February 1, 2018

**Re: Ceja Vista Unit 1A-1E, 2, 3 – (DRB 1004428)
Request approval of Amended Preliminary Plat**

Thank you for meeting with us on Tuesday to resolve some of the outstanding issues with this project. The following is an update on my understanding of what was agreed upon as well as the revisions to the infrastructure list and comments received at the DRB hearing:

AMENDED PRELIMINARY PLAT FOR
CEJA VISTA SUBDIVISION
UNITS 1 A, 1 B, 1 C, 2 AND 3
 WITHIN THE
TOWN OF ATRISCO GRANT
 PROJECTED SECTION 9
 TOWNSHIP 9 NORTH, RANGE 2 EAST, NMPM
 CITY OF ALBUQUERQUE
 BERNALILLO COUNTY, NEW MEXICO
 DECEMBER, 2017

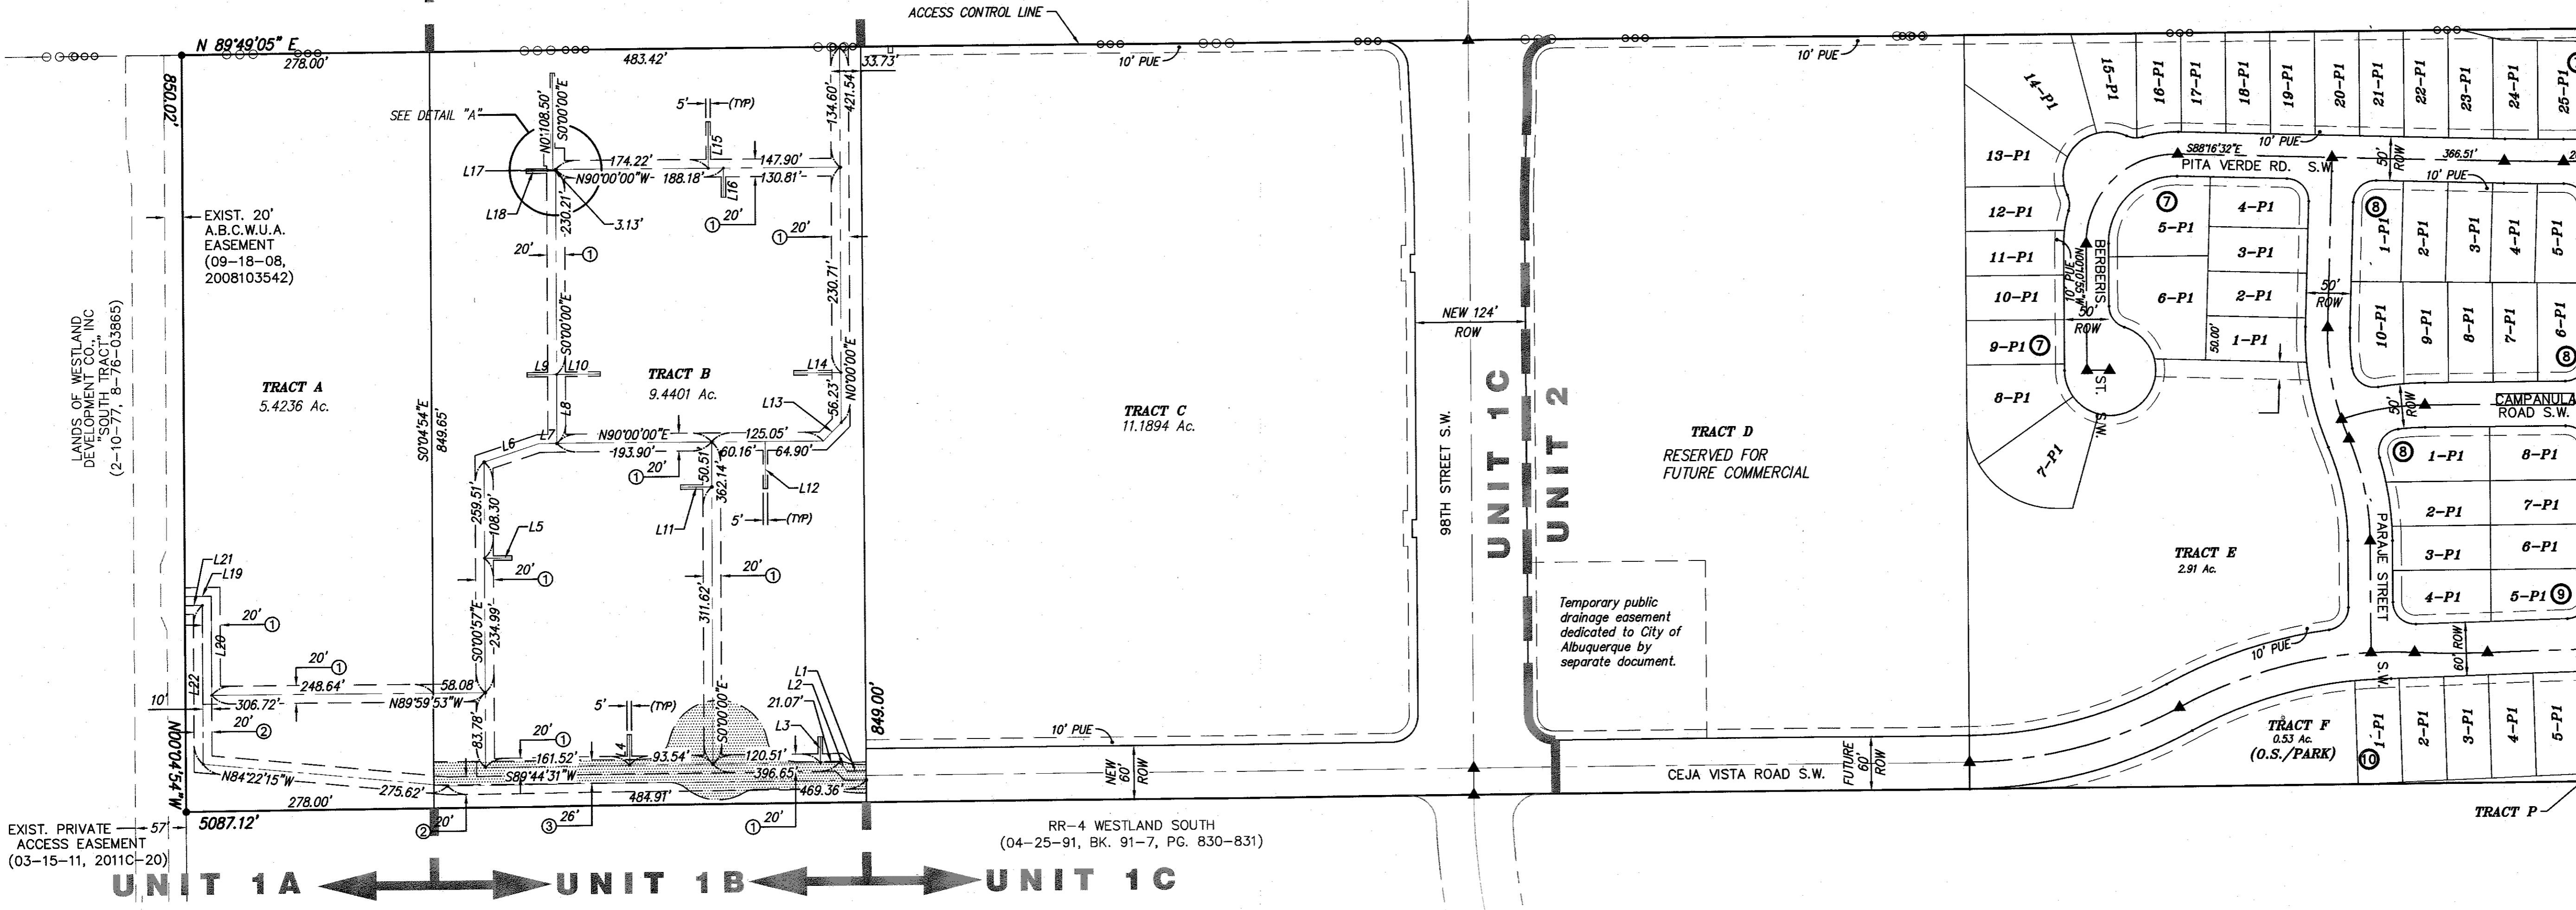
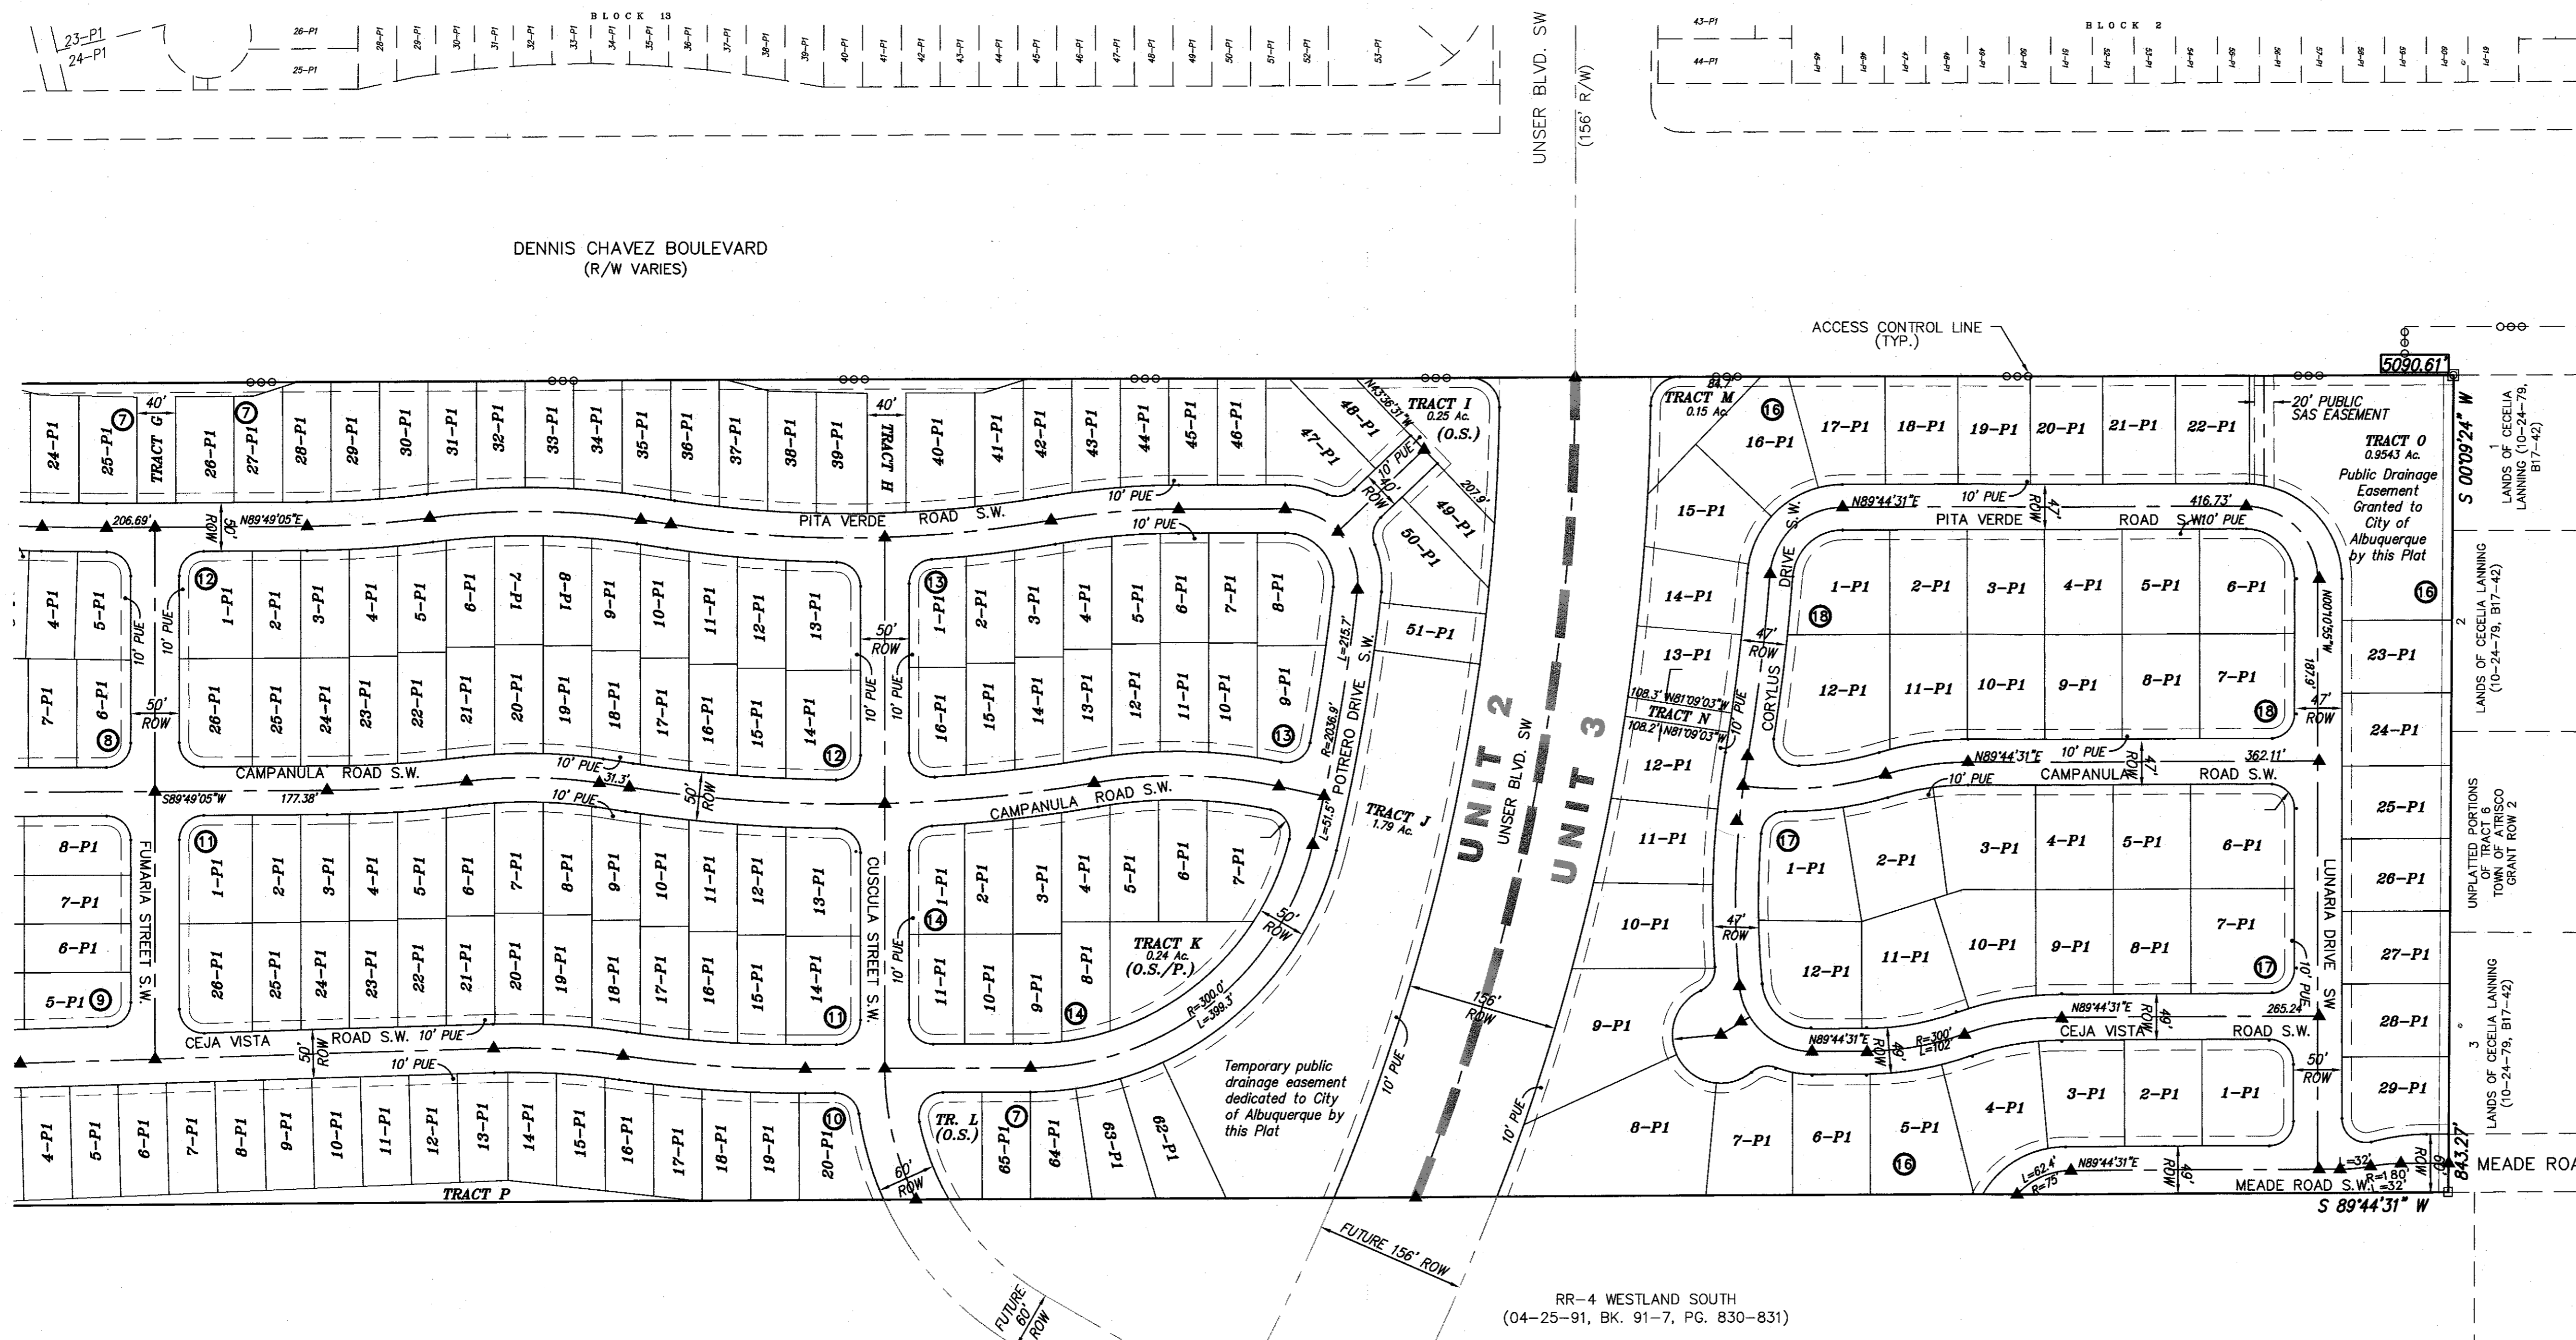
7. The existing 60' easement is being replaced with the right of way dedication, similar to the 98th street dedication. There is no vacation intended adjacent to proposed Tract C.
8. Unit 2- 6" WL along Berberis Str has been corrected.
9. Unit 3- The Tract designation were inadvertently changed and have been revised to the former designations. These have all been checked and revised.
